Kirklees Council

Development Management

Application 2025/90893 – 7 Frank Lane, Thornhill

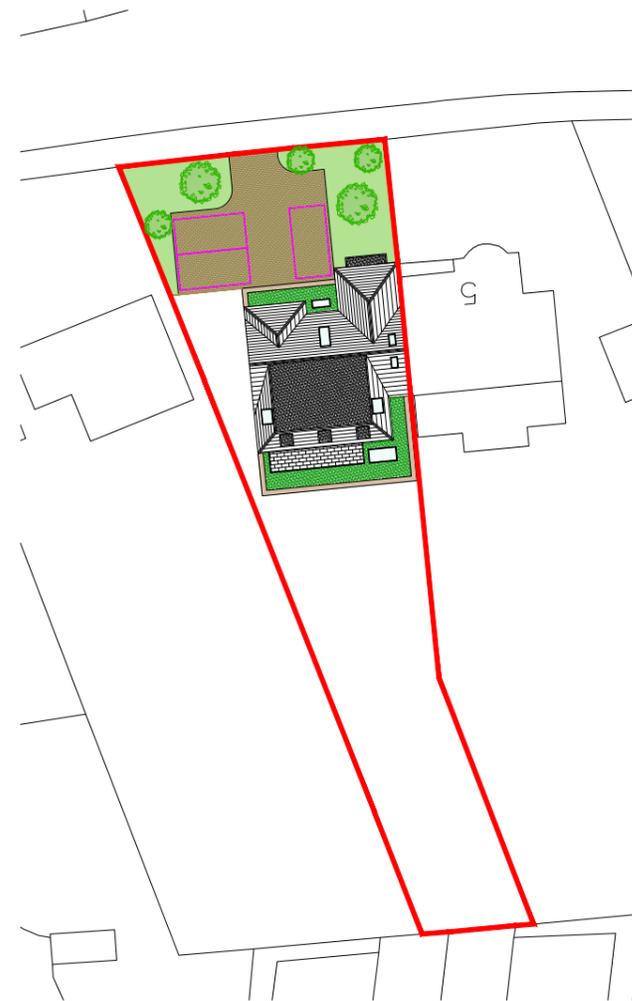
It is worthy of mention that my clients remain concerned that the building will be too close to the boundary. It is most important that the existing boundary wall is preserved and that any building works should allow sufficient room for access to the wall.
